**CITY OF ALBUQUERQUE
PLANNING DEPARTMENT**

**August 20, 2014
DRB Comments**

PROJECT # 1009988

RE: Lot 3, Block 4, Sandia Research Park

Plat for
Lots 3-A, 3-B and 3-C, Block 4
Sandia Research Park

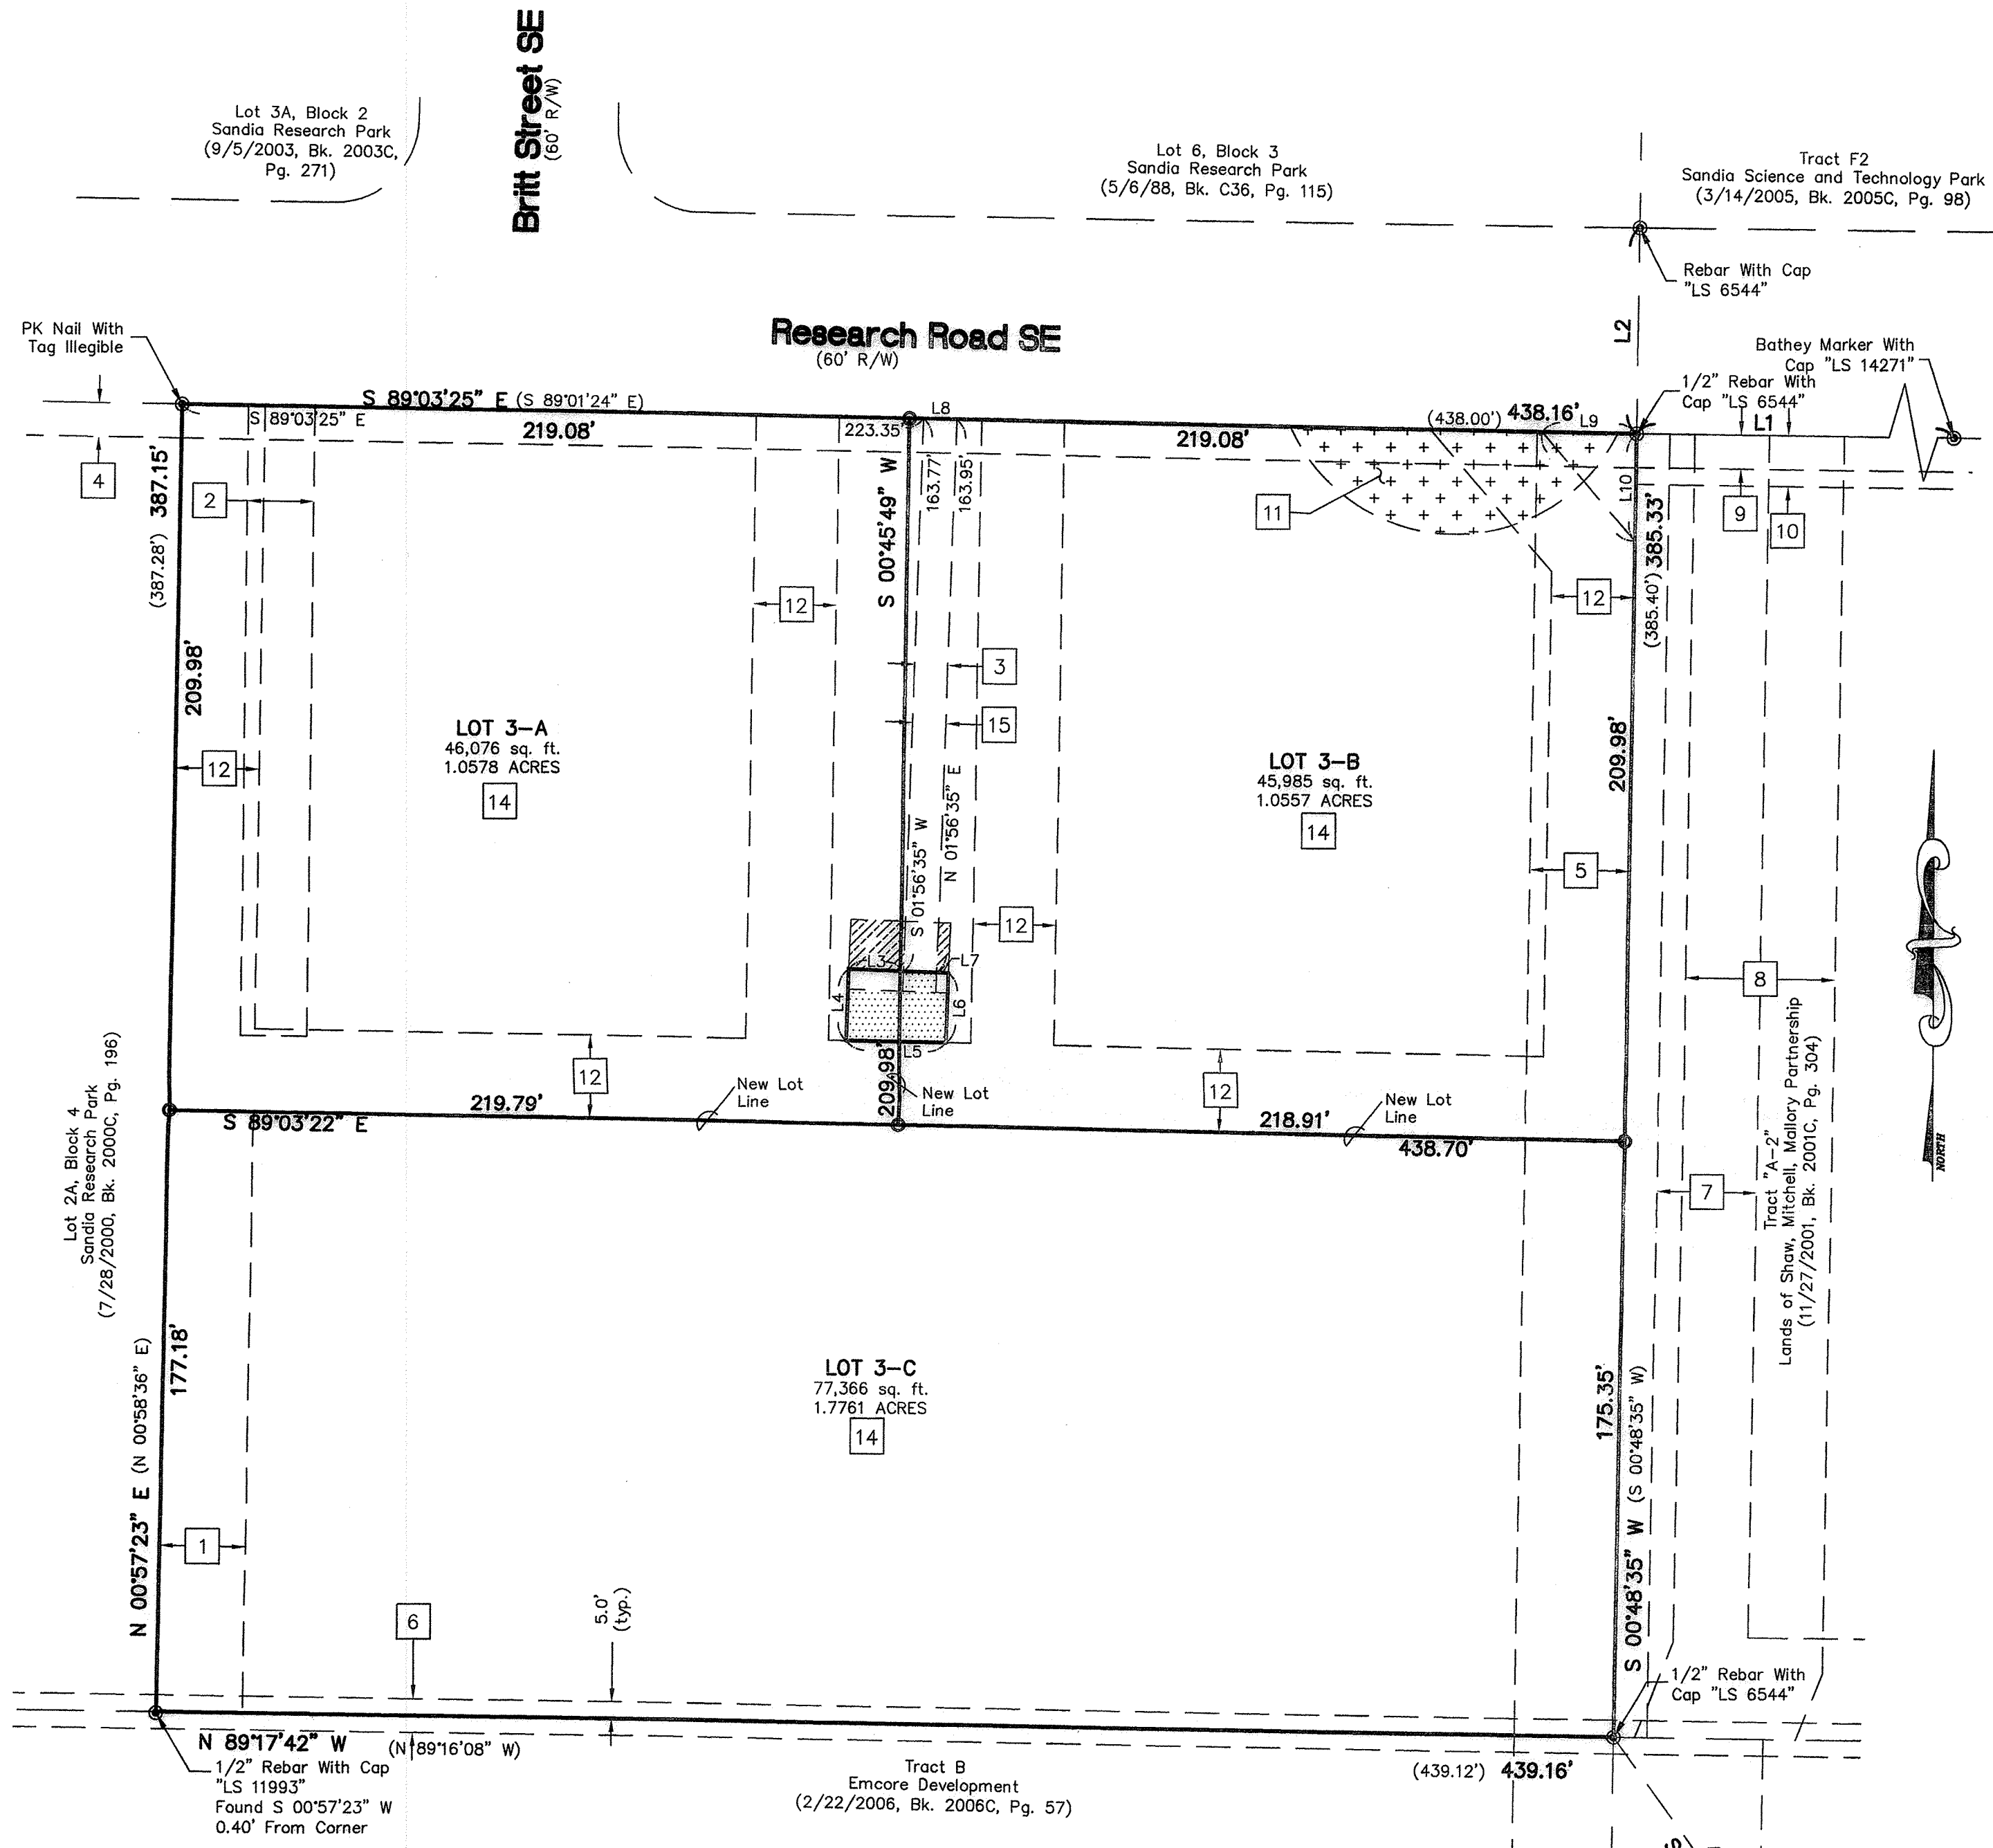
Even the vacation of private easements requires a specific, separate DRB application (Form V).
